OXFORDSHIRE COUNTY COUNCIL'S RESPONSE TO CONSULTATION ON THE FOLLOWING DEVELOPMENT PROPOSAL

Application no: 17/00316/F

Proposal: Application for engineering operations to include the creation of pond through associated bunding to serve consented residential development (ref. 11/00617/OUT, 12/01802/REM).

Location: Land South Of Blackwood Place And Molyneux Drive And North West Of Cotefield Farm, Oxford Road, Bodicote.

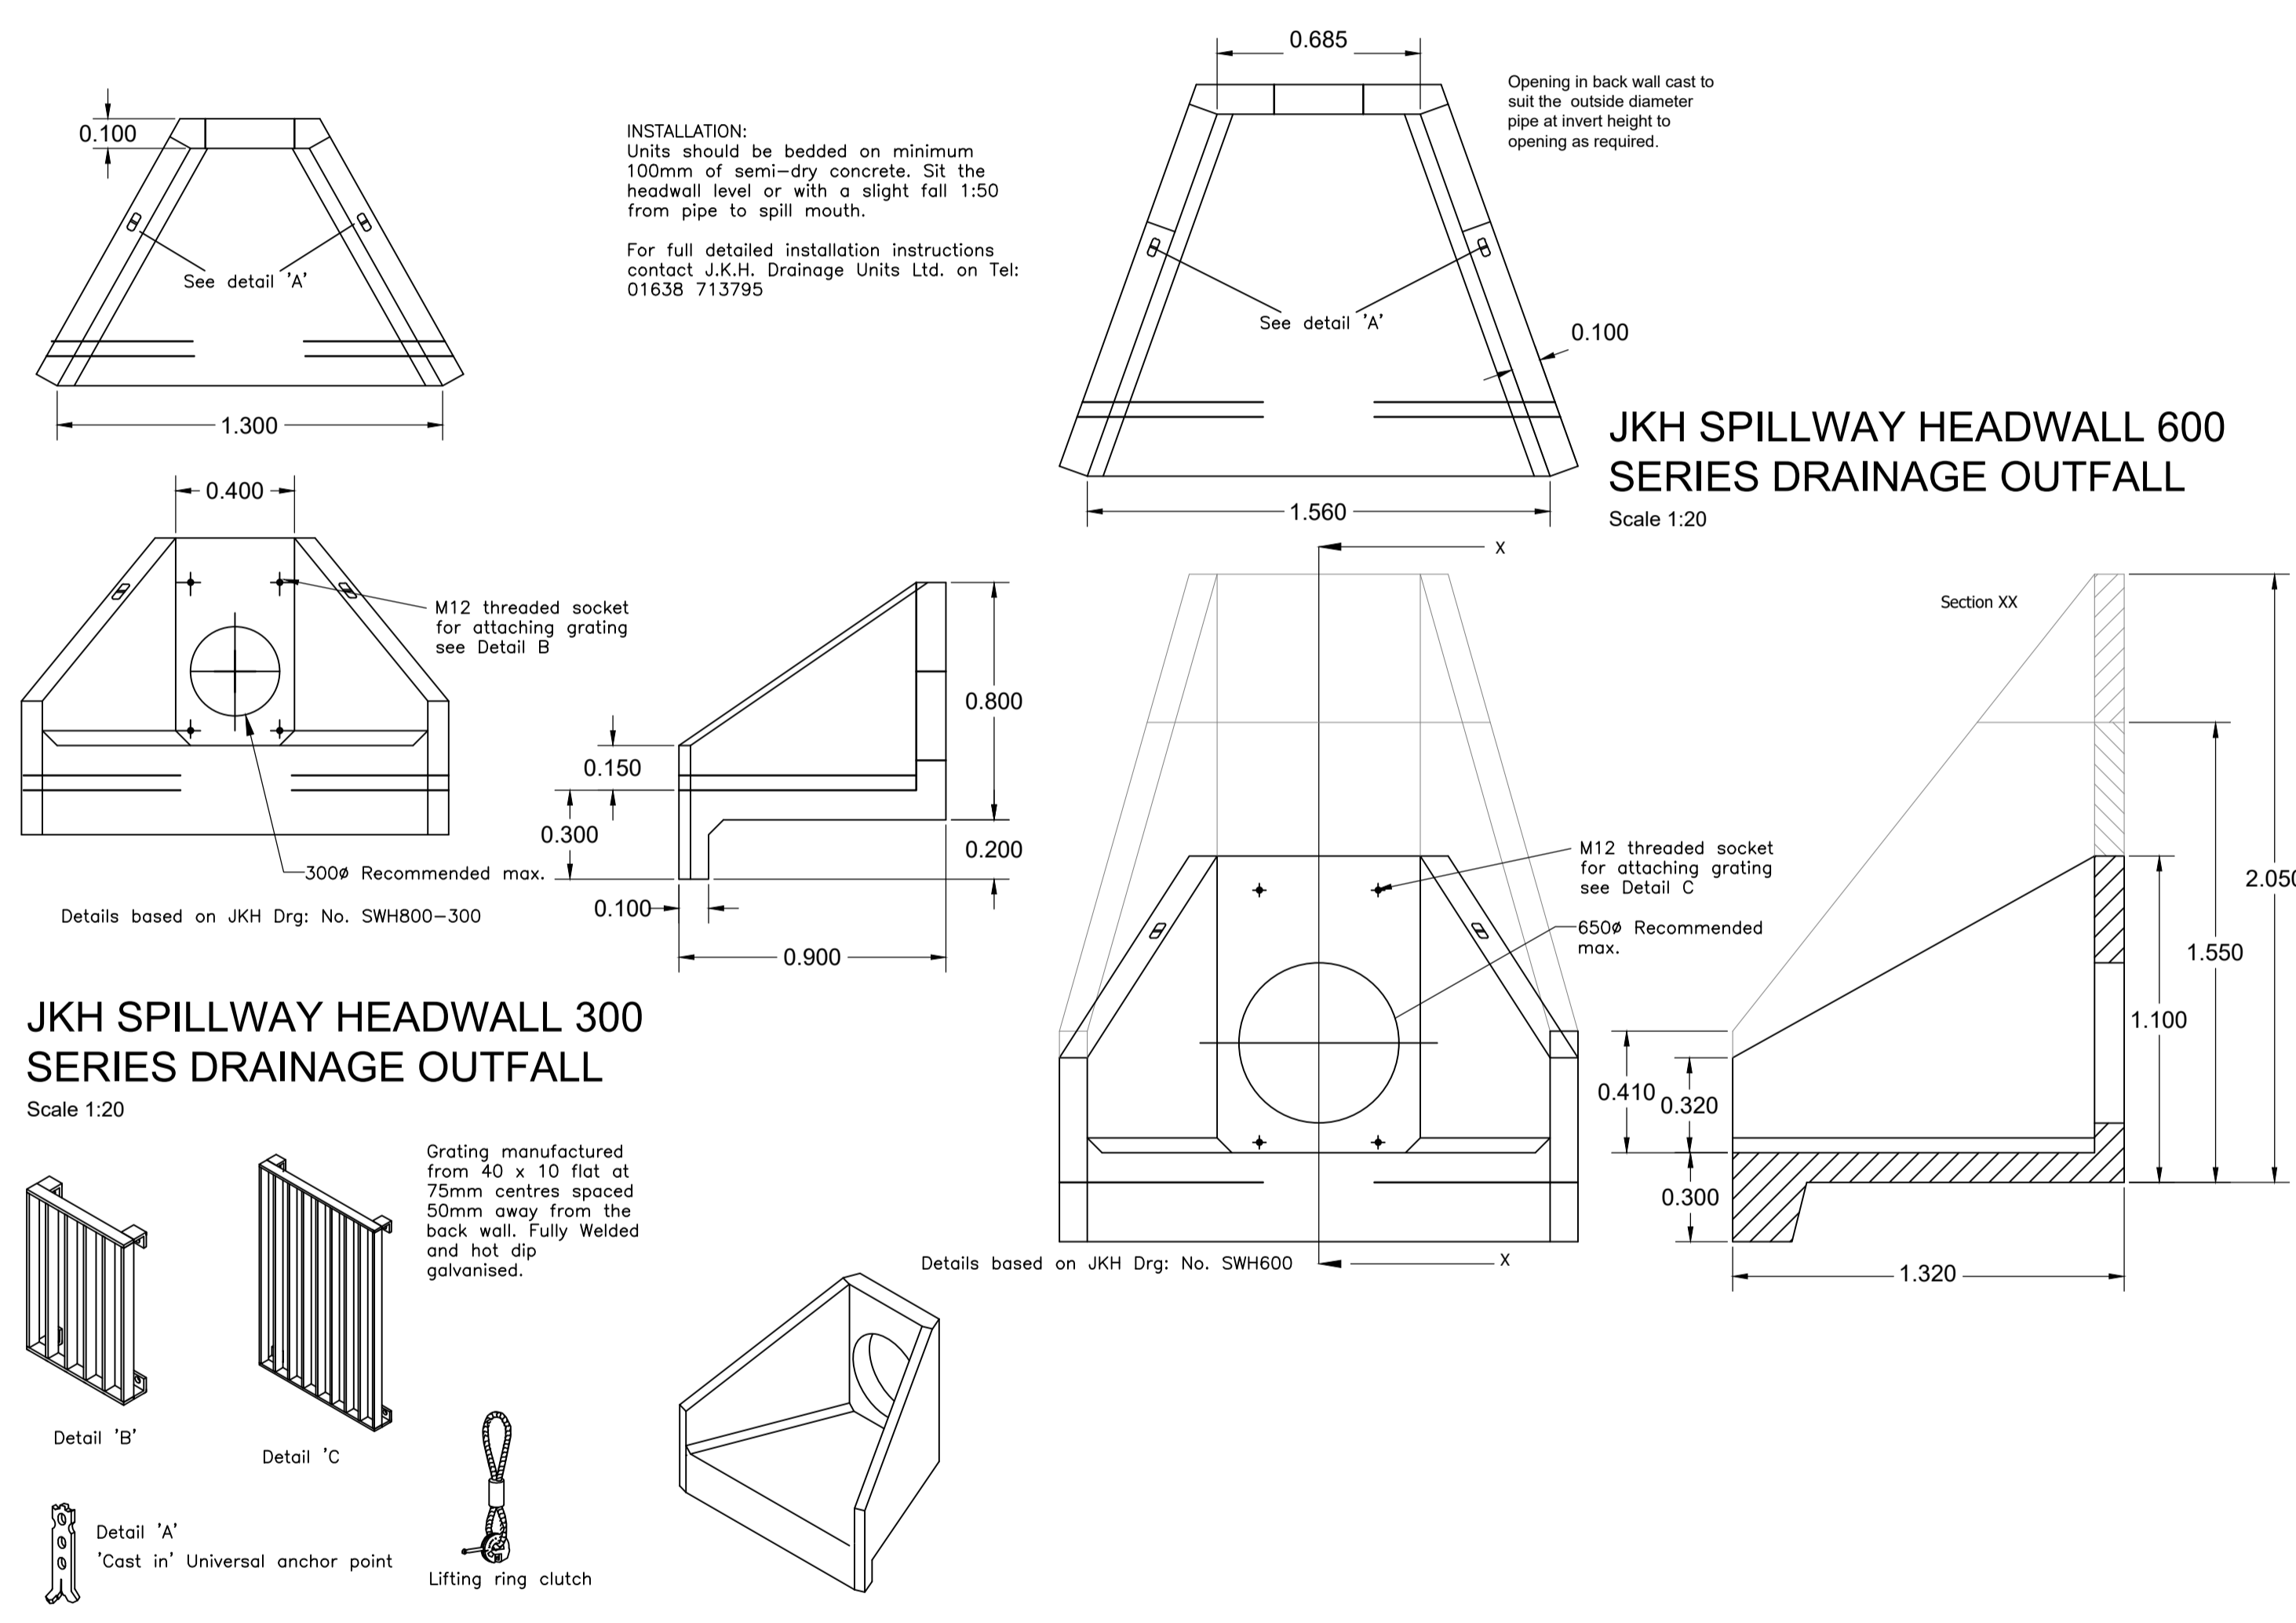
These are shown on drawing 15031-316 B – 'Adoptable Headwall' – The outfall shall be fitted with a grill. The screen should be positioned so that the angle to the horizontal is 45 degrees.
